**Re: Objection to Substitute Consent Application ref: PL93.305618**

**Applicant: Meitheal Trá na Rinne Teo**

**Application Description: Oyster Processing Facility**

**At: Moat, Ring, Dungarvan, Co. Waterford**

SITE LAYOUT PLAN

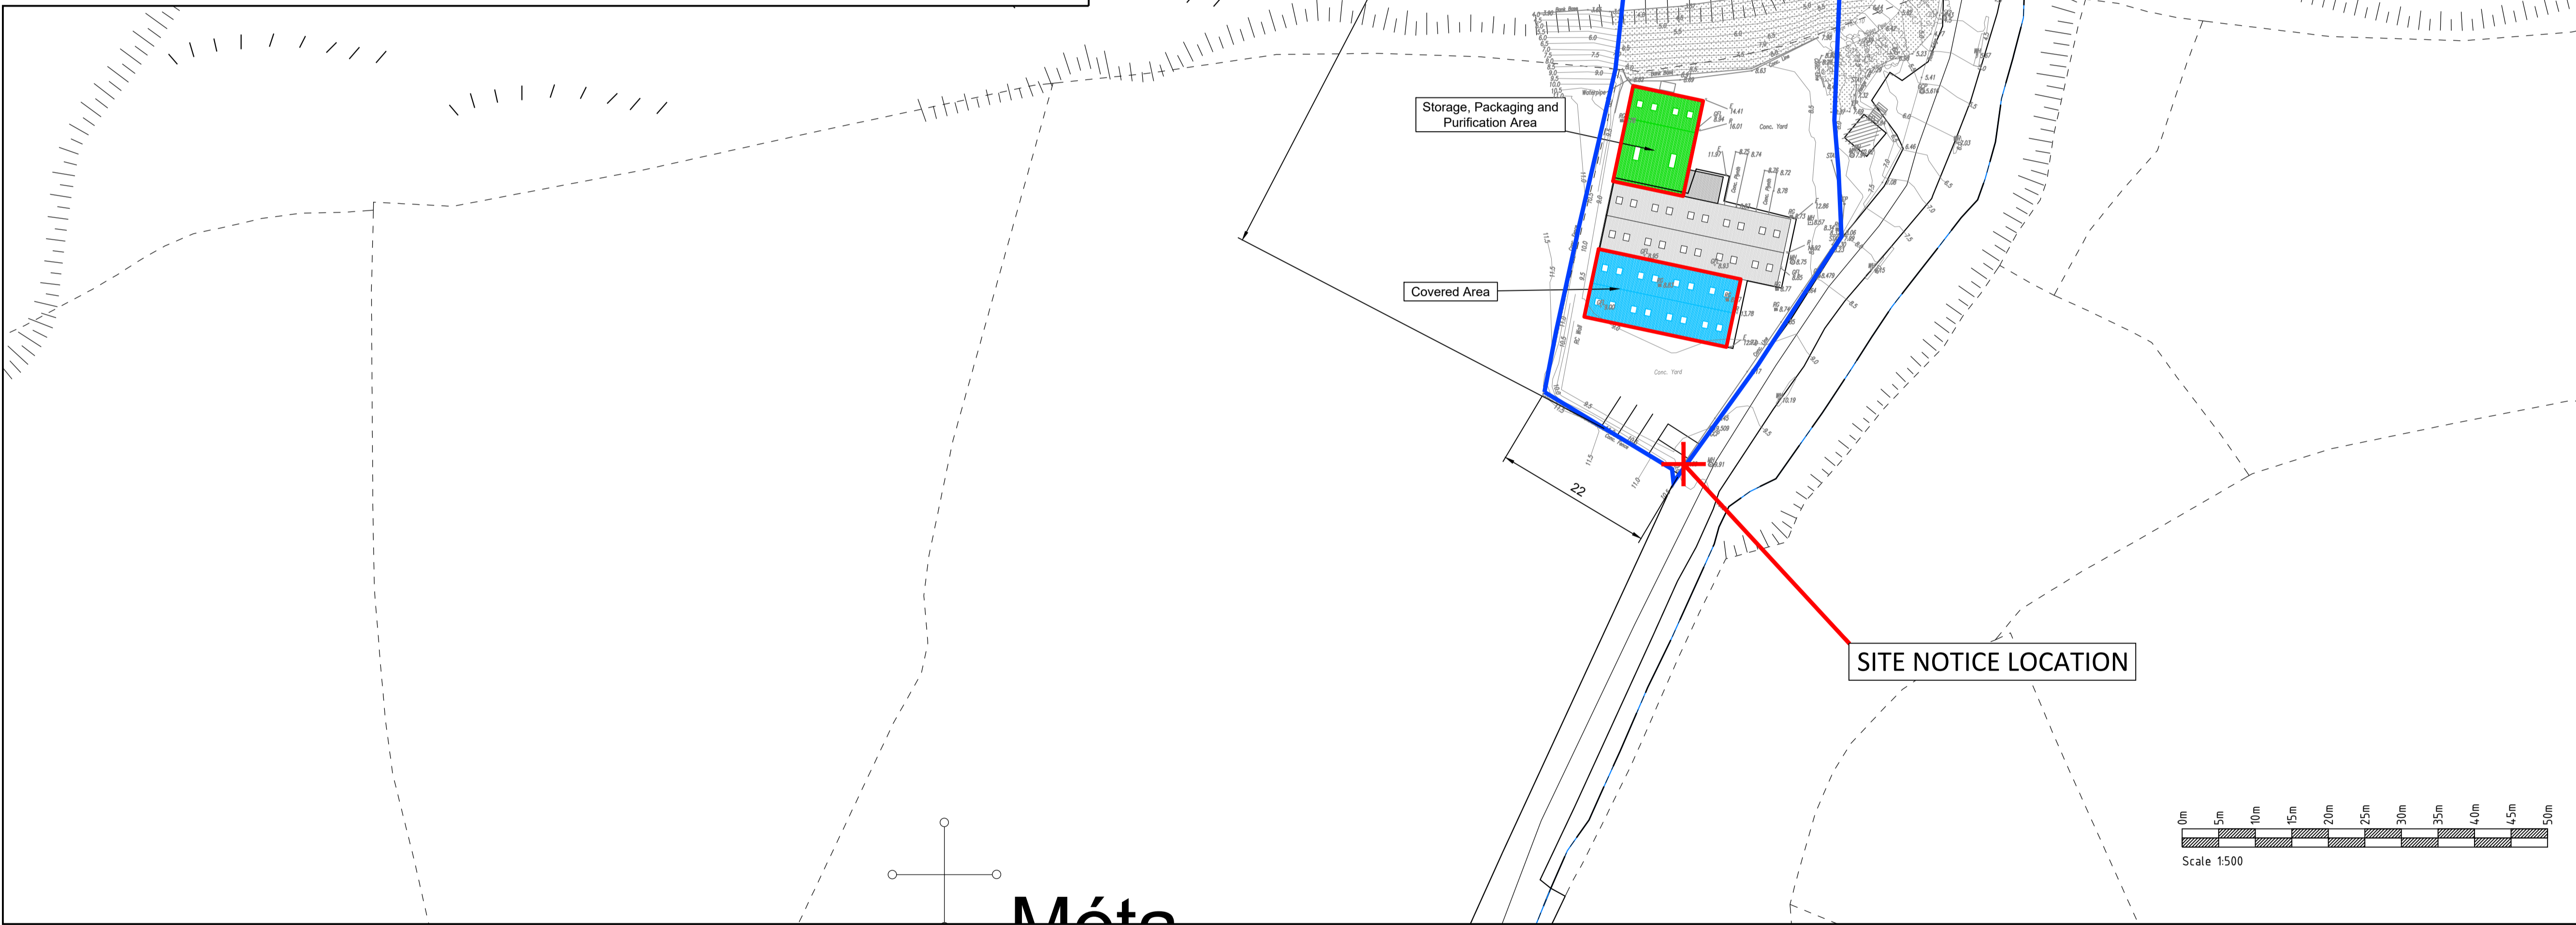
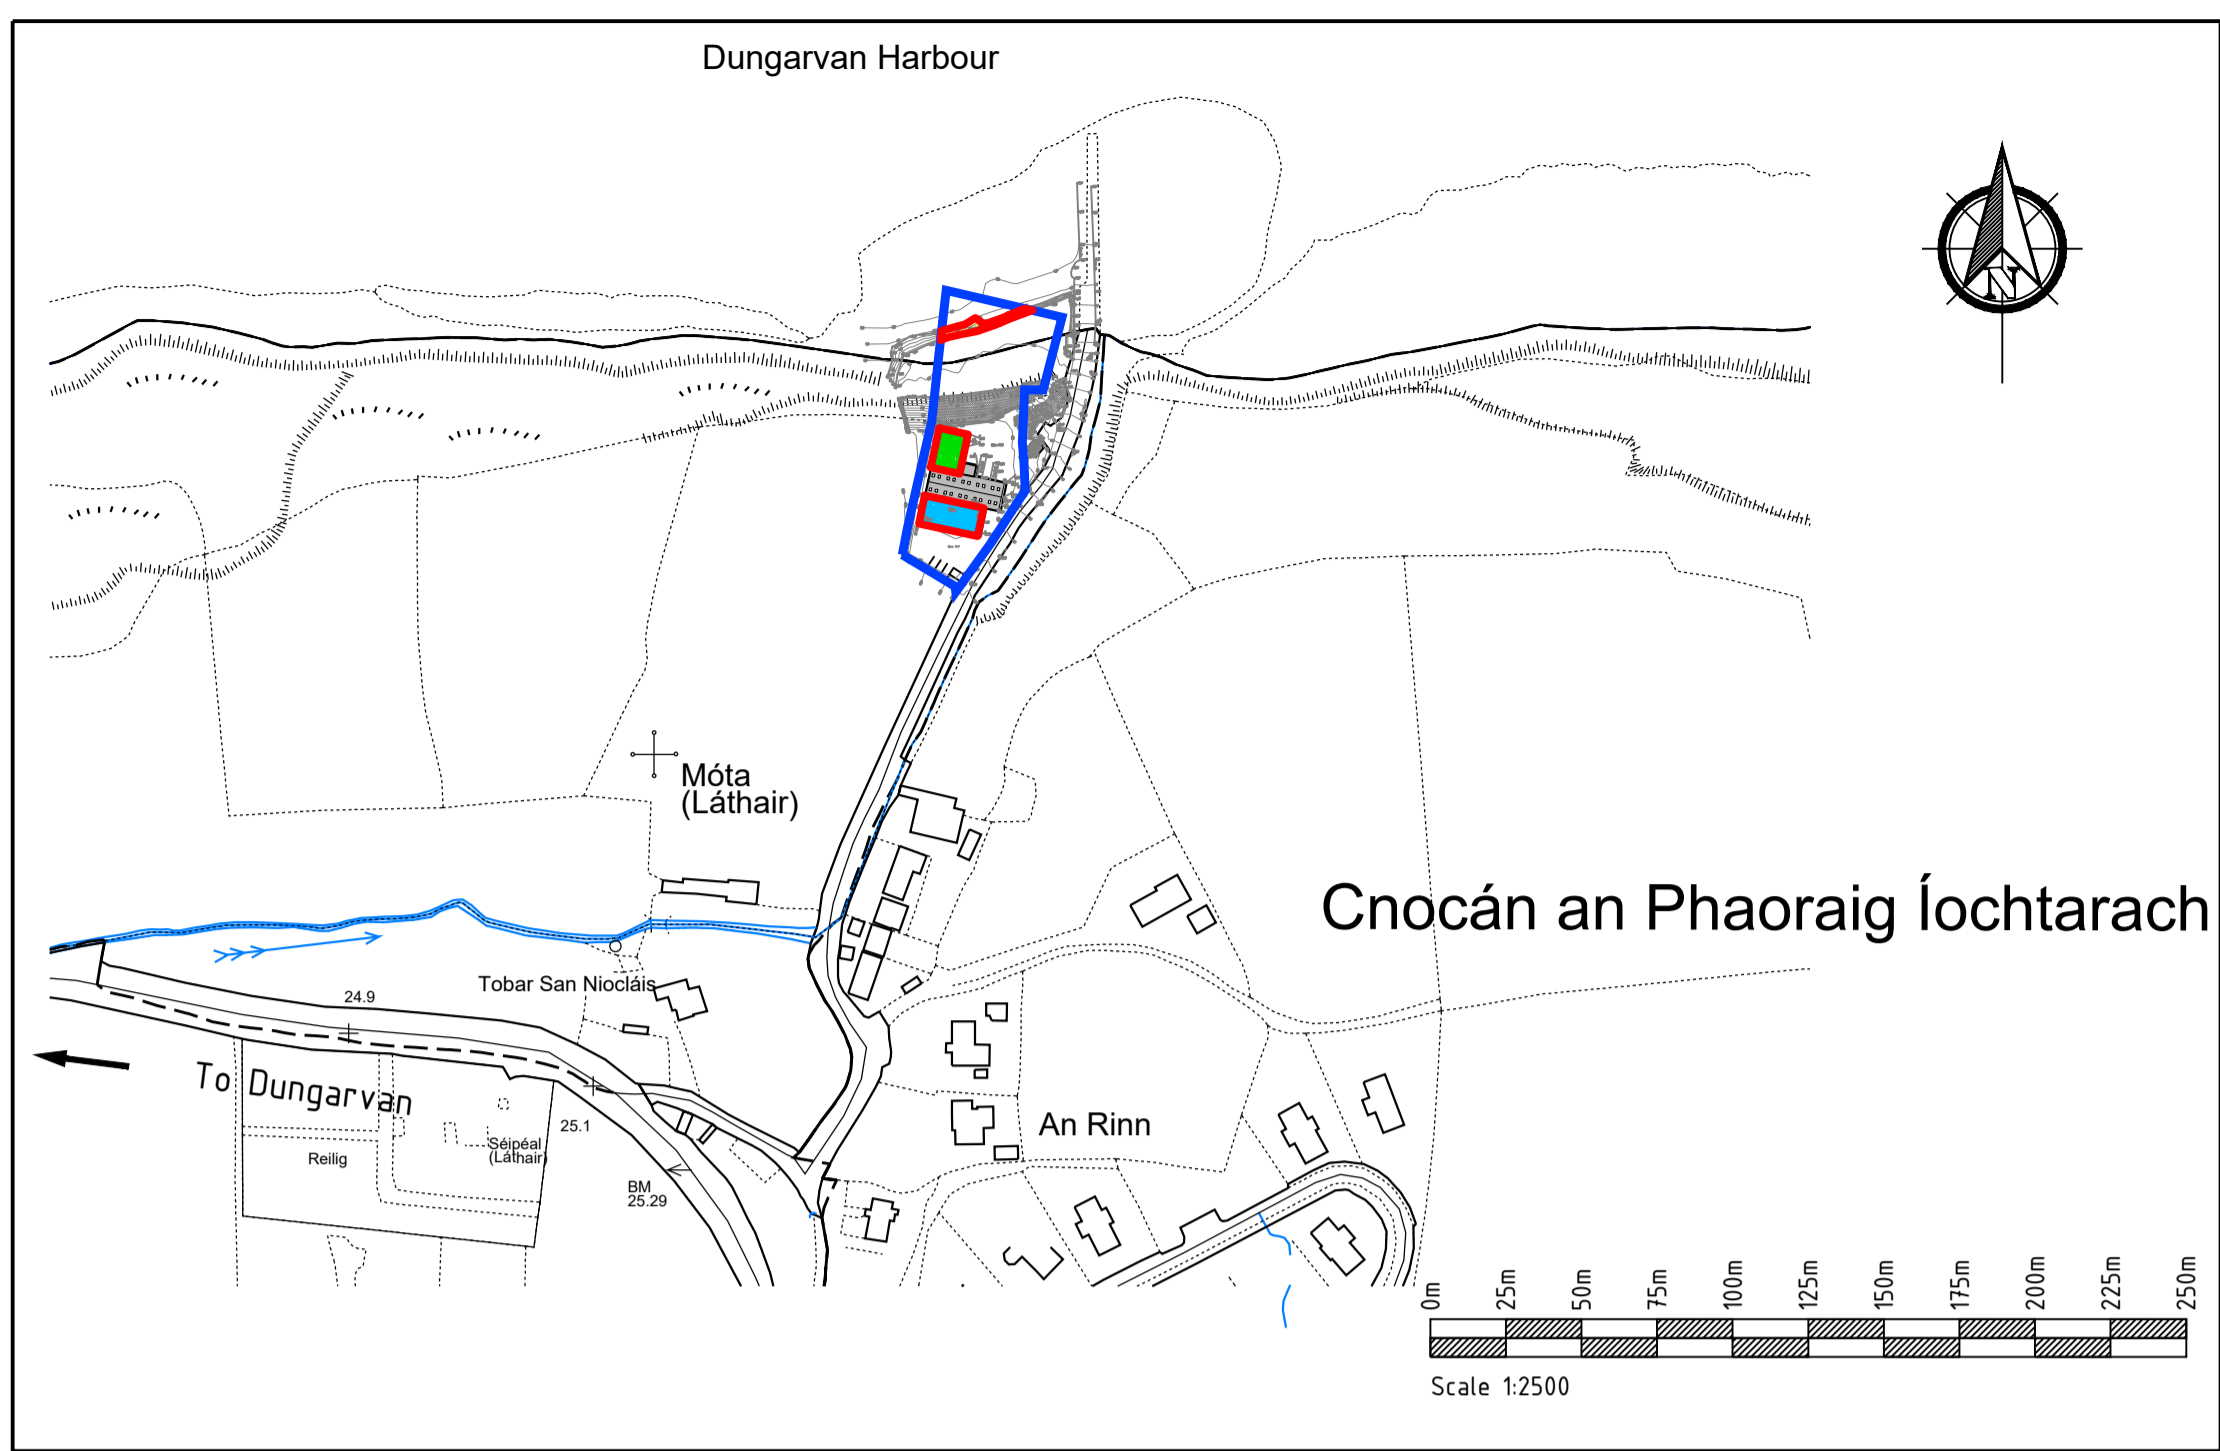
Finally, I listed the outcomes the Group sought from the process which included the Board not consenting to the rock revetment in its present location and its removal along with the entire lower yard. This would result in the reinstatement of all of the lands below the High-Water Mark to the foreshore beach and the unrestricted public along the foreshore.

As the application for Substitute Consent did not include for the unauthorised lower yard or all of the rock revetment, the entirety of the oyster processing facility as exists (as shown on the site layout plan accompanying the EIA Screening Report), was not examined in the AA Screening Report and RNIS.

**Figure 1-2: Site Layout**

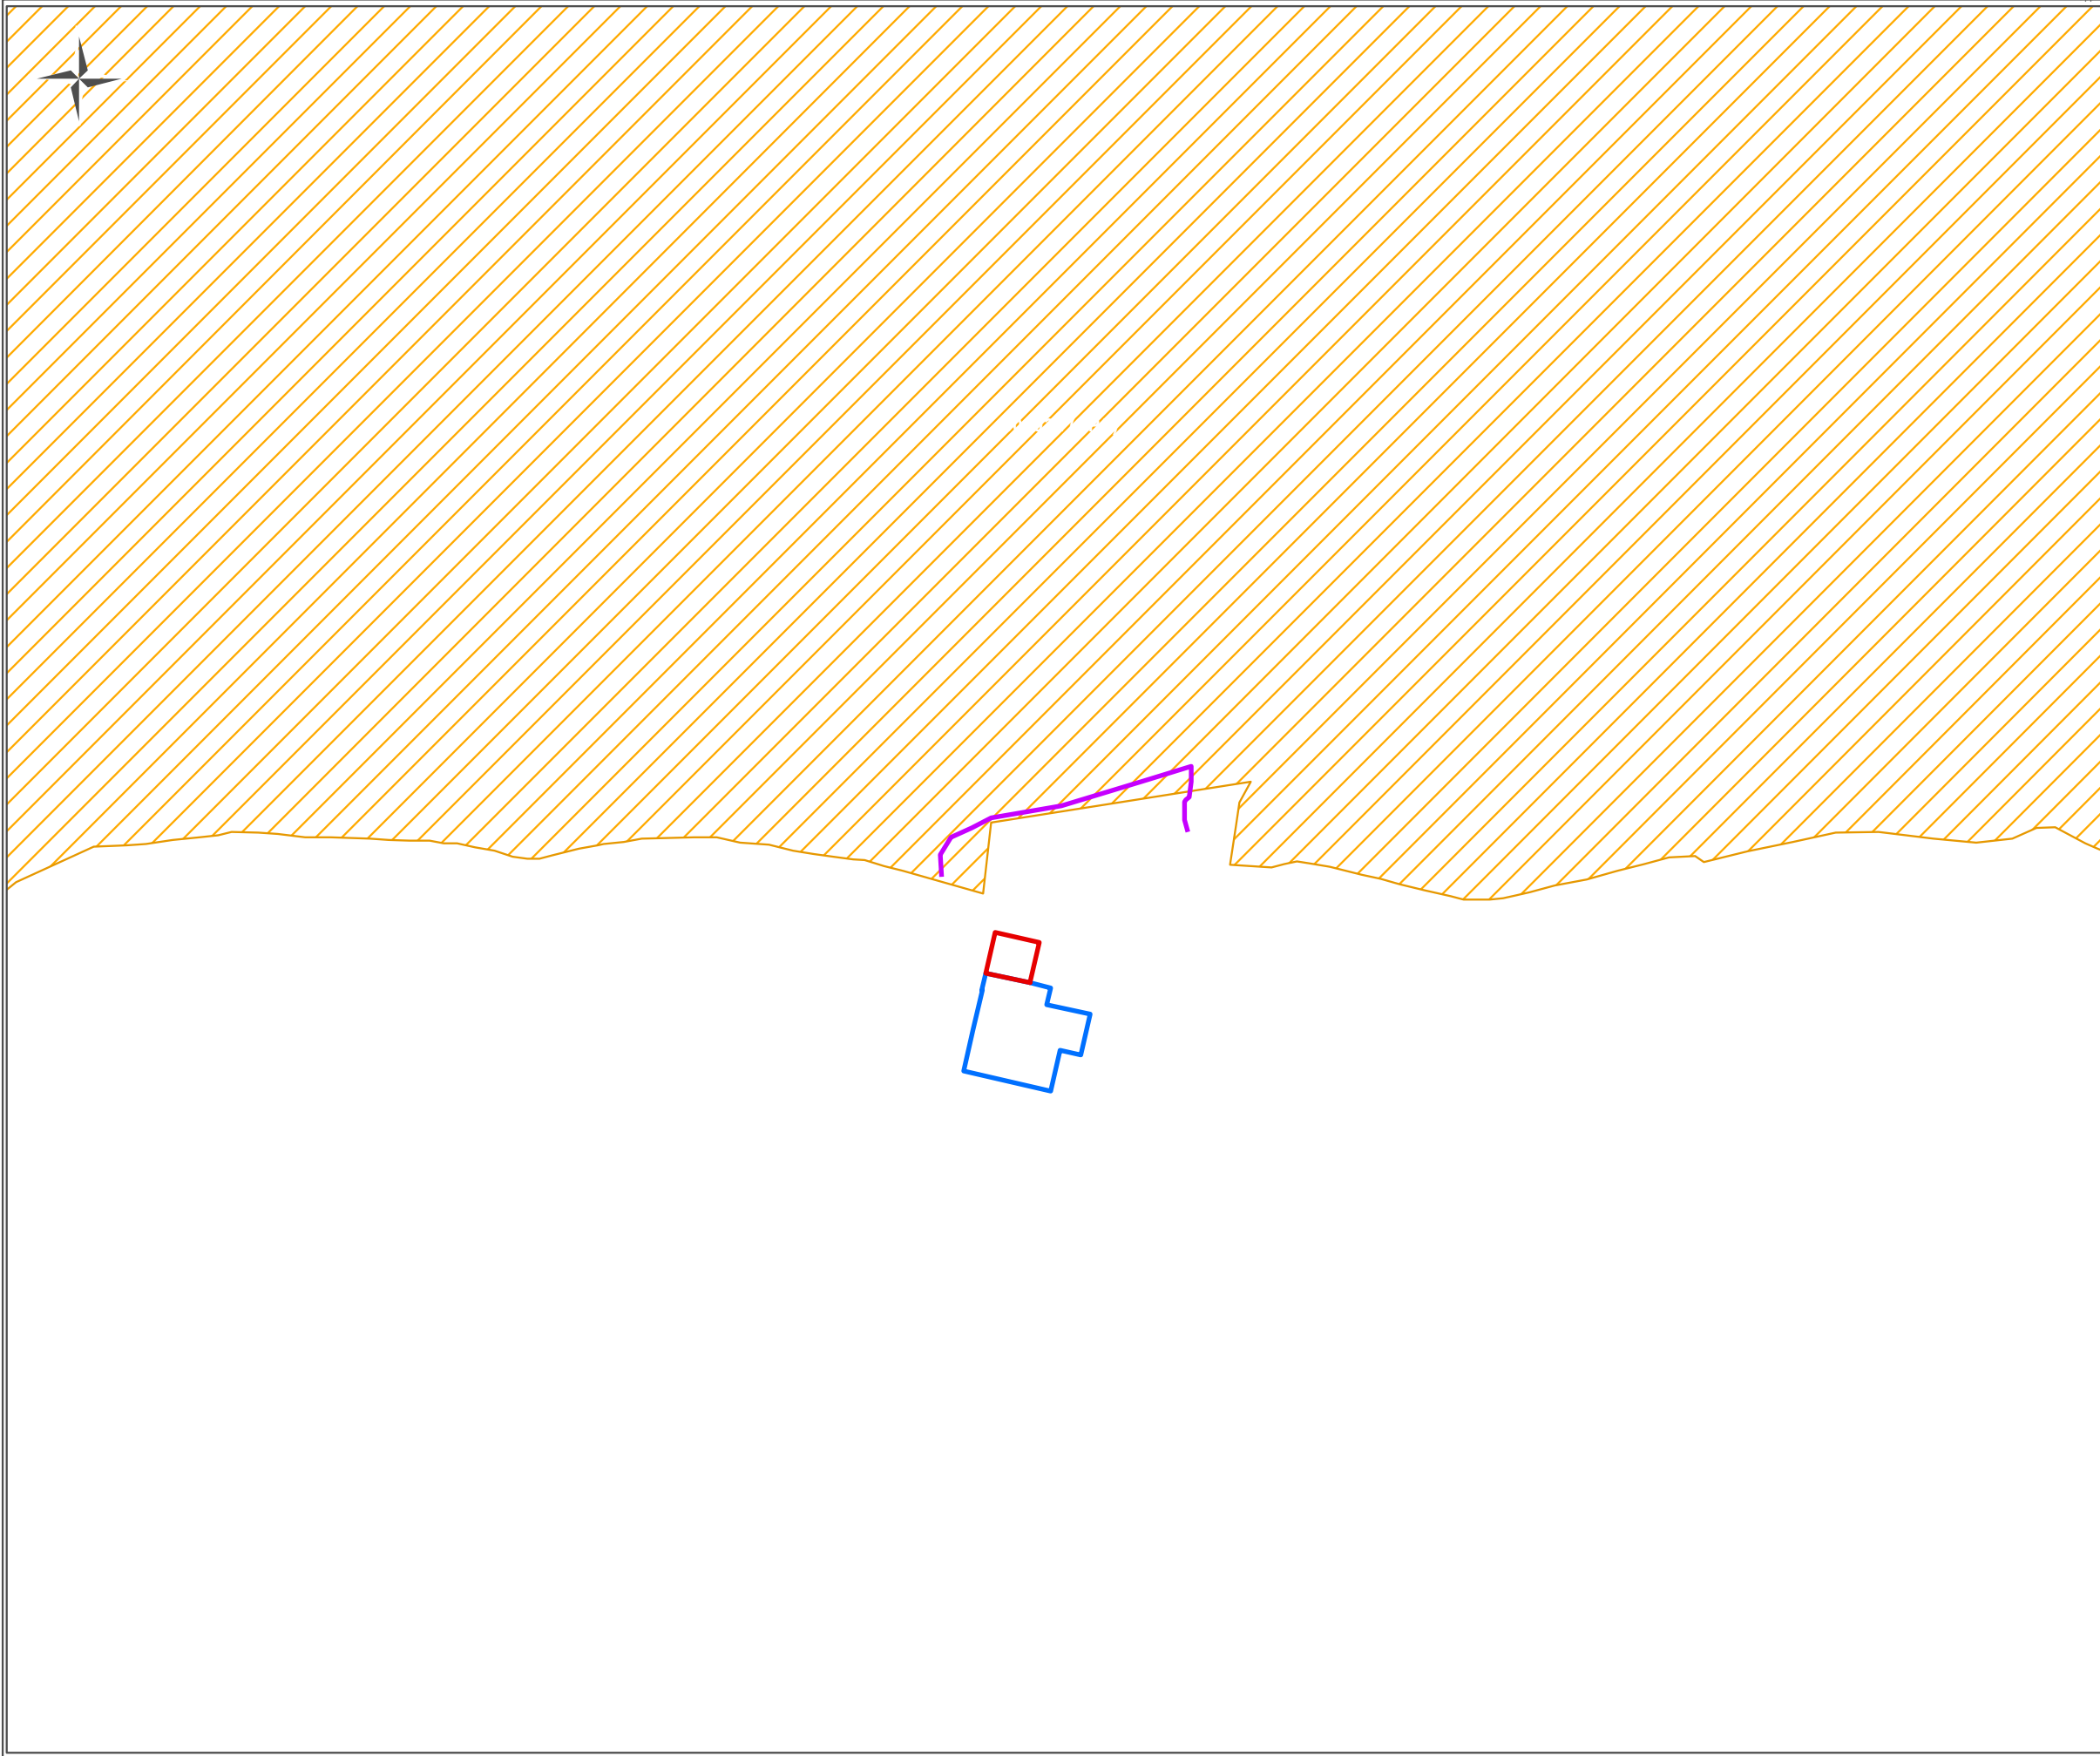
- Figure 1.2 of the Stage One Appropriate Assessment Screening Report and Stage Two Remedial Natura Impact Statement confirms the vast majority of the rock revetment is within the SPA boundary.
- The application and associated documents do not address the water abstraction equipment associated with the development which is within the SPA.
